CITY OF ALBUQUERQUE

April 22, 2022

RE: Slim Chicken
8240 Montgomery Blvd NE
Grading and Drainage Plans
Engineer's Stamp Date: 02/22/21
Hydrology File: G19D004E

Based upon the information provided in your submittal received 04/06/2022, the Grading & Drainage Plan **is not** approved for Building Permit and for action by the DRB on Site Plan for Building Permit. The following comments need to be addressed for approval of the above referenced project:

SECTION C-C

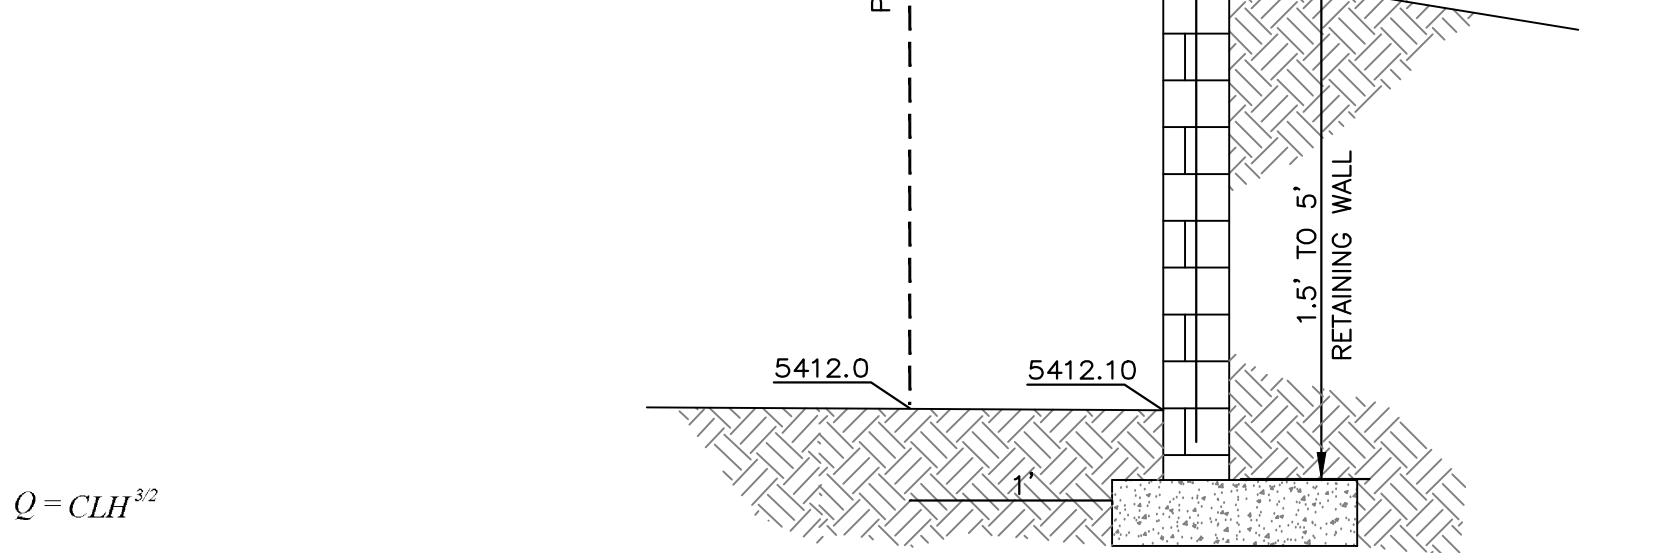
1. Please show the entire scope of the work to be done with this Permit. Below is the Approved Interim Grading & Drainage Plan for this Tract and entrance into Montgomery. Now show all the limits of the entrance. Most of this was demolished so that this site needs to build the entrance with curbs on both sides. The proposed sidewalk along the eastern part of the entrance needs to be labeled, "Sidewalk to be constructed un CPN # 568483. The existing line work within Montgomery needs to be shaded back so that the proposed work pops.

- Please add the flowline at the curb return at the Montgomery entrance.

- Where is the extent of the paving along the southeast corner of the development?

- There is a missing CMU block wall on the plan that is shown in Section B-B.

- Noticed that there is paving to be done on Tract B. It also appears that a majority of the drive (access road for the overall commercial) is on Tract B but should still be split between Tract A and Tract B. Please contact Transportation on this issue. Hydrology

will need written letter from the Owner of Tract B authorizing the work to be done within Tract. This letter needs to be notarized.

6. It appears that there is a lot of work on Tract B that should actually be on Tract A. This should slide over a little to make it work.

7. The separation between the drive-thru and the oncoming traffic from Montgomery should be a curb and not just stripped. Please contact Transportation for approval.

8. Please add both the existing conditions and the proposed condition calculations on the Grading & Drainage Plan. Reference to the overall development drainage manage plan is nice but the calculations are still needed on this sheet. The majority of Montgomery Blvd is not need, so the calculations can be place there.

9. Please provide the weir calculations, per DPM Article 6-16(A), for the curb cuts. A coefficient of 2.7 is typically used for the weir equation $Q = CLH^{2/3}$.

10. The entire Tract A needs to follow the approved overall development drainage management plan. See the wording below form that plan.

COMMERCIAL BASIN "A" AND "B" WILL DRAIN SOUTH TO A PROPOSED DROP INLET LOCATED JUST NORTH OF WYMONT CIRCLE. THOSE FLOWS WILL BE CONVEYED THROUGH STORM SEWER TO THE WATER QUALITY POND. BASIN "C" WILL DISCHARGE TO A PROPOSED DROP INLET AT THE ENTRANCE ON MONTGOMERY AND DRAIN VIA STORM SEWER TO THE DROP INLET THAT CAPTURES BASINS "A" & "B".

This site currently violates this approved plan with curb cuts into depressed landscaping areas that do not drain anywhere or drains into Montgomery Blvd which is not allowed.
